F/7/13/NMA

Application for a non-material amendment following a grant of planning permission.
Town and Country Planning Act 1990

DEMOLITION OF EXISTING GARAGE

+ ERECTION OF NEW GARAGE

DATE: 15.04.2012 DRG. NO. 01

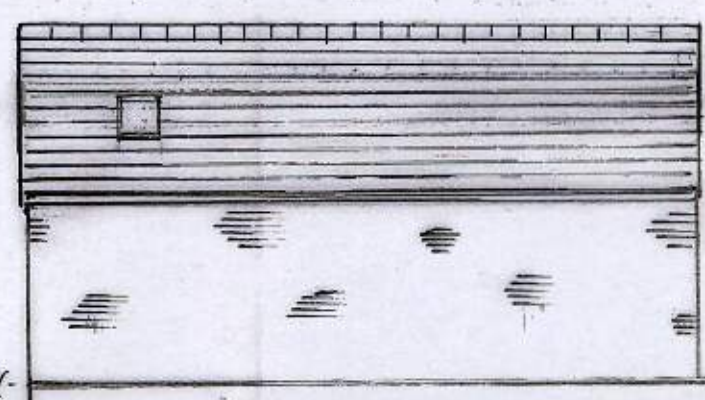
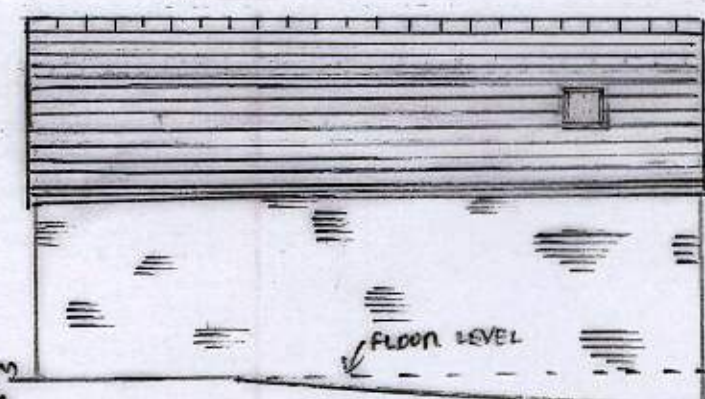
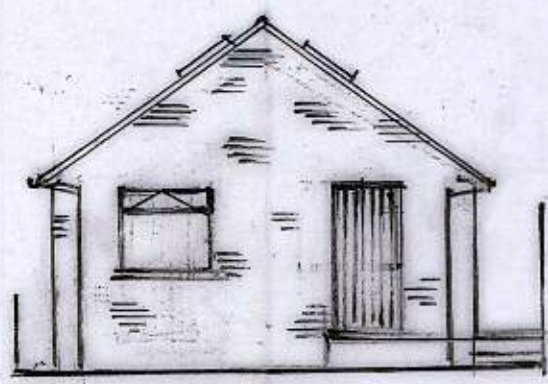
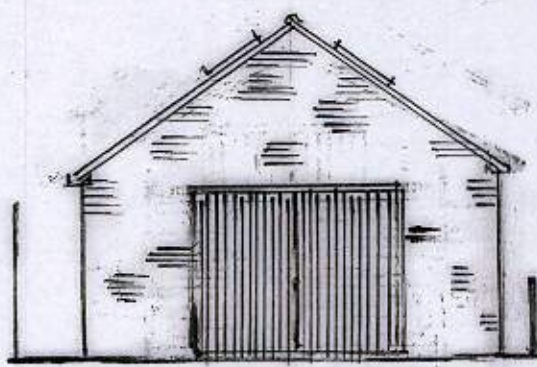
① SLIGHT VARIATION OF ROOF PITCH TO ACCOMMODATE
CHARN TILES

② NARROWING OF DOOR OPENING TO DOOR AT FRONT OF PROPOSED GARAGE

① STEEPEN PITCH REQUIRED FOR TILES

② SIDE HUNG DOOR REQUIRE NARROWER OPENING
